TECHNICAL NOTE			
from:	ALAN DAVIES	date:	28/3/2022
subject:	Land at the North of the Chapel Hill site Longridge for the erection of 4no. commercial units (Use Class E).	file ref:	J1354-TN1

A detailed planning application has been submitted with supporting Transport Statement, this has been reviewed and clarification is sort on a number of areas.

Scale 1:200 1:500 Drawing No.  
 By: I Pawsen  
 Date: Oct 2021  
 Job No. 4021 / 3  
 Am. F

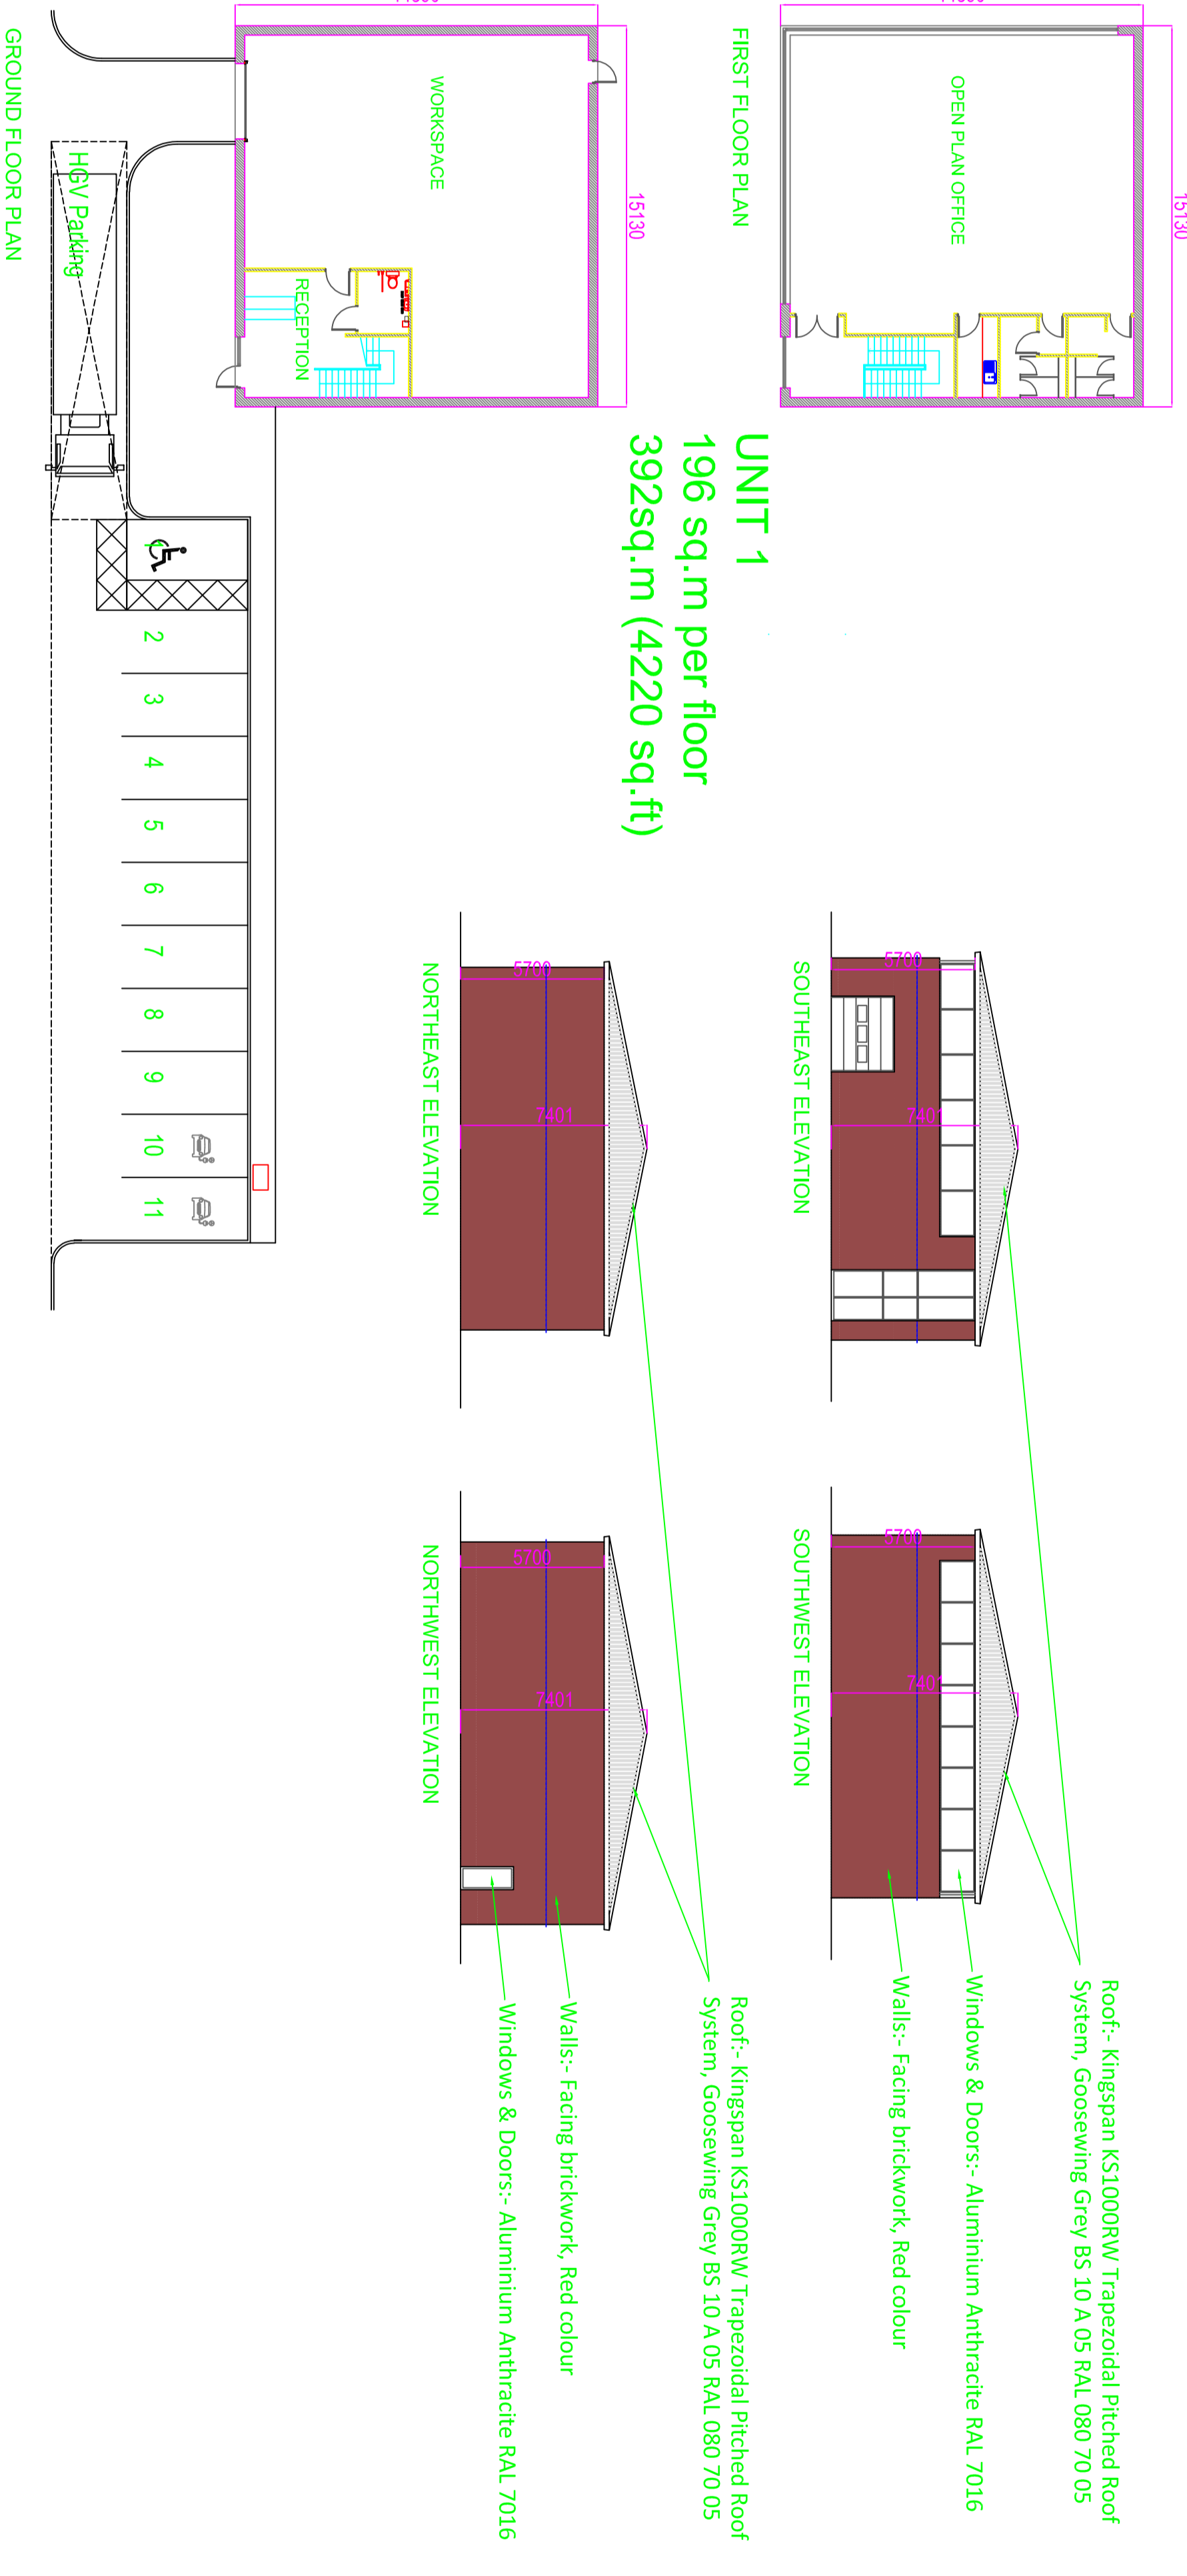
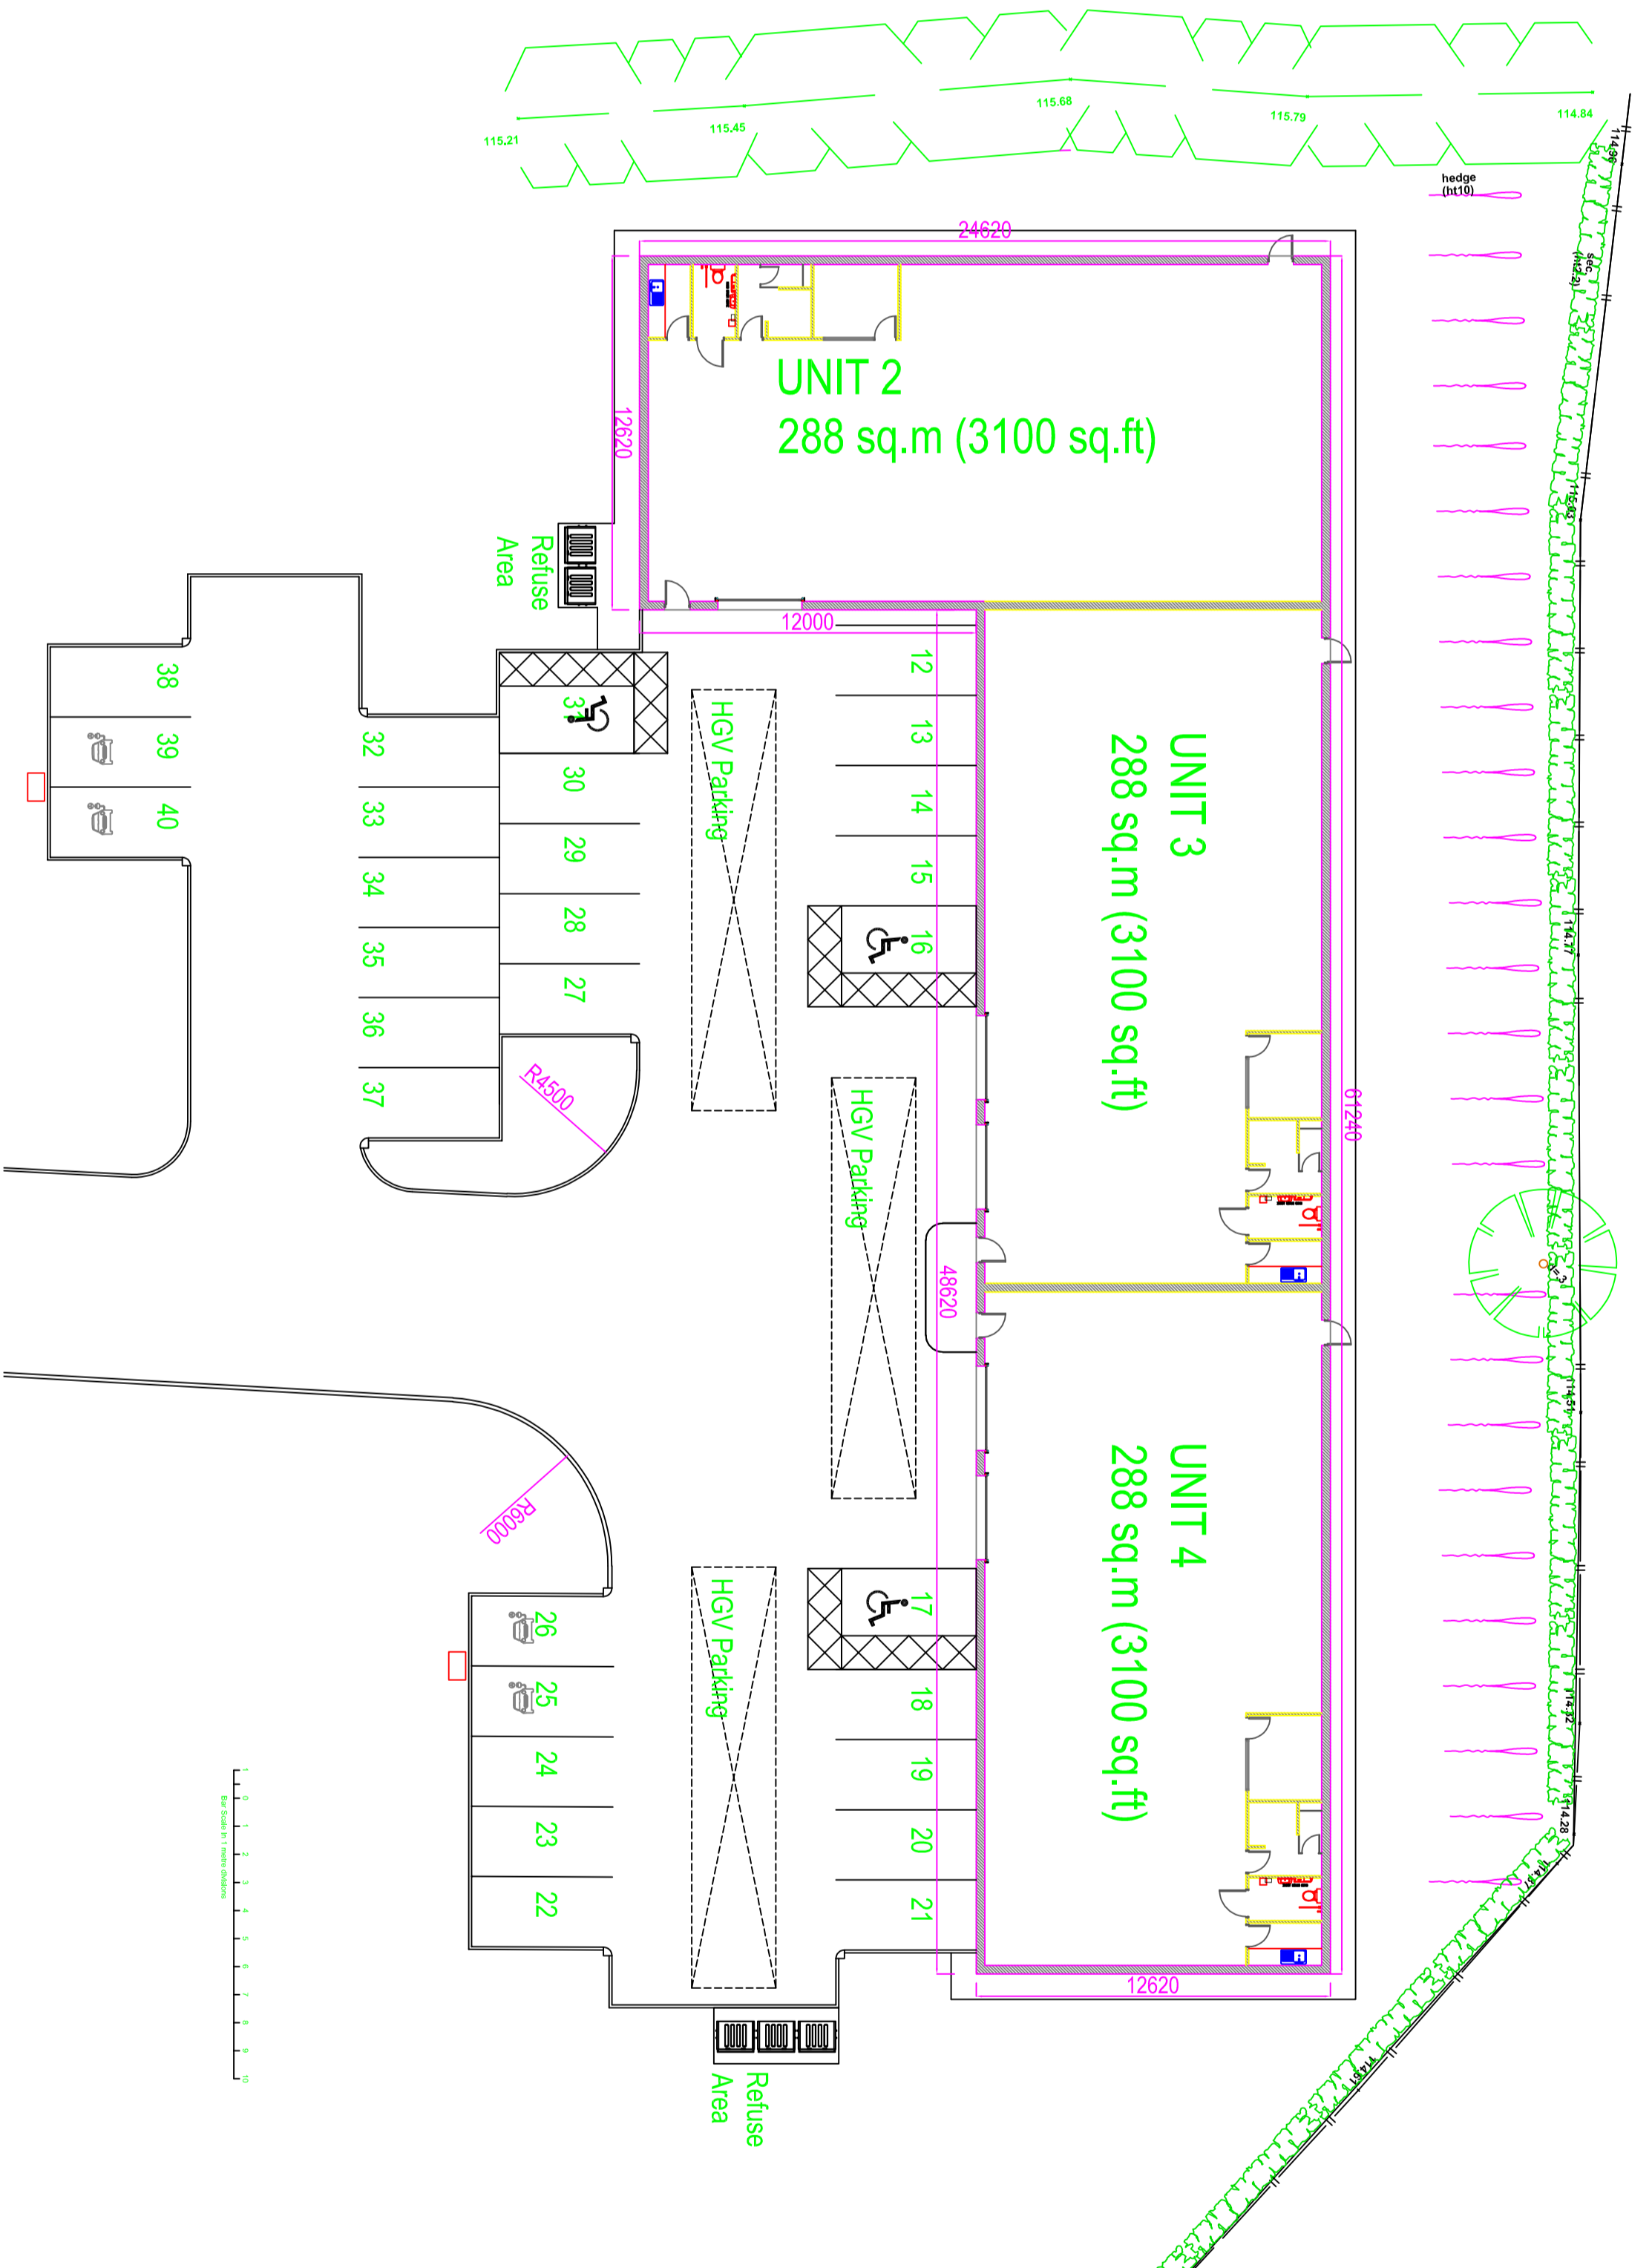
The LHA have reviewed IP drawing number 3 Rev B titled "Plans and Elevations As Proposed" and are aware that the site will provide 30 car parking spaces for the proposal. This however does not comply with the parking standards found in the Joint Lancashire Structure Plan, which requires a B1 development in Longridge with the internal floor area of 1256 square metres (sqm) to provide 40 car parking spaces.

It is worth noting that the LHA are aware that the site is in close proximity to bus stops which serve services to Preston and the Longridge area. However, should visitors to the site travel from outside these areas, the most likely mode of travel is by vehicle leading to the need for further car parking spaces to serve the site. Therefore, the LHA require the additional 10 spaces to enable the site to comply with the LHAs guidance. This should be shown on a revised plan.

The LHA also require on the revised plan a loading area for Unit 1. This is because currently there is no area for servicing for Unit 1 and so the LHA are concerned that any servicing vehicles will block the use of the internal road into and out the site. The LHA advise that the area should be located adjacent to the Unit,

The dimensions of the loading area should be a minimum of 2.4m x 15m as a guide to enable Heavy Good Vehicles (HGV) to use the space but the LHA will require a tracking drawing to ensure that the proposed dimensions are adequate

The LHA require the space to be large enough for an HGV to use because there is a lack of designated areas for HGVs to park within the site. Not only this but should an HGV or another delivery vehicle be servicing one of the other units, the area can then be used as a waiting area until the vehicle exits the site.

The parking offered was based on location an operational needs of the site which is based on the national policy framework, the increase to 40 to meet the maximum

policy levels ignores this however the extra 10 spaces are shown on the revised drawings and the abstract below.

Spaces 37 to 40 will be designed as overspill spaces i.e. crushed stone construction to be used if and when needed.

A maximum rigid vehicle of 12m has been tracked for the revised internals, the spaces are designed to accommodate the size of vehicle and other than at unit 1 no requirement to mark out as they form the aisles etc.
